**Kevin Cox**  
**Crime Prevention Design Advisor**  
Thames Valley Police Headquarters South  
Oxford Road  
Kidlington  
Oxfordshire  
OX5 2NX

**REF: 22/02025/REM**

**Location: Bicester Gateway Business Park Wendlebury  
Road Chesterton**

04 November 2022

Drawing Title
EXTERNAL LIGHTING

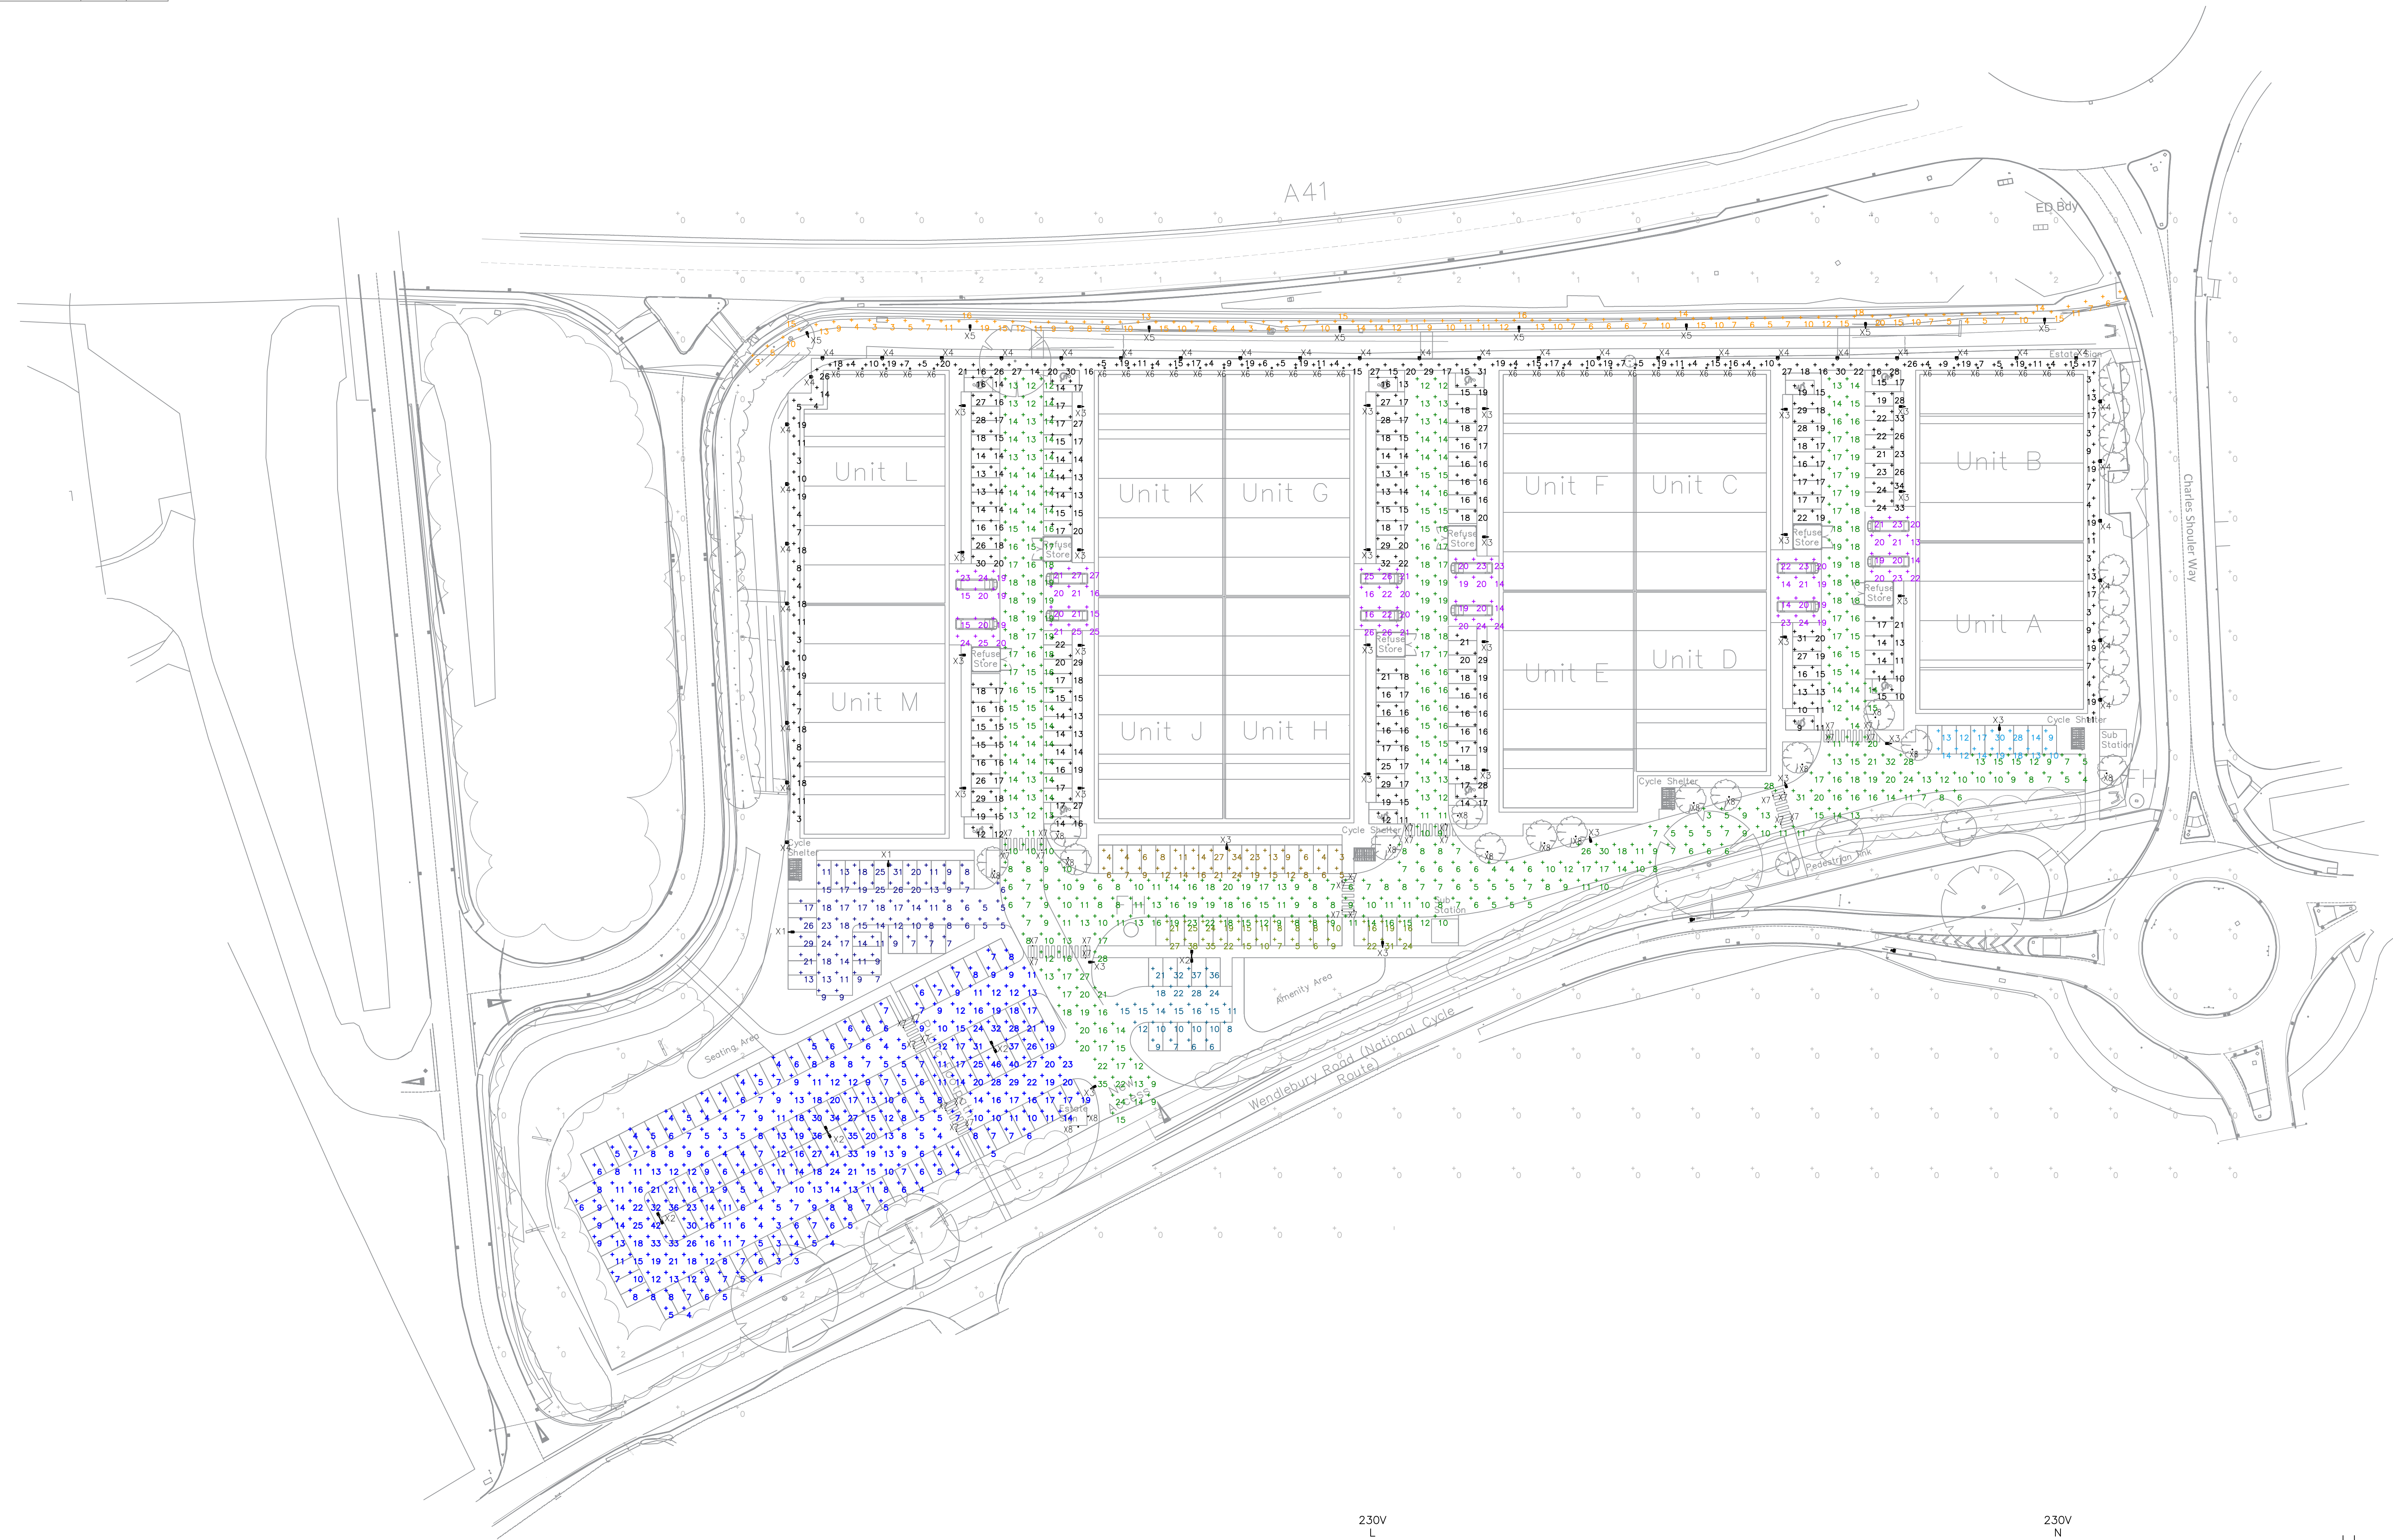
- Surveillance opportunities to the south of the car parking area are reduced as parking is located away from buildings, only overlooked by a parking area of adjacent development. I recommend parking is located where it is well overlooked by the buildings that it serves, and additional protection in the form of formal surveillance (CCTV) should also be provided.

- The parking area is fully accessible and open, leaving it at risk of crime, ASB and illegal encampments, particularly late at night or during periods of low occupation. I recommend all private car parking areas are protected with boundary treatments, landscaping and barriers to prevent unauthorised access. Height restriction barriers should also be provided for areas away from buildings that are intended for car parking only.
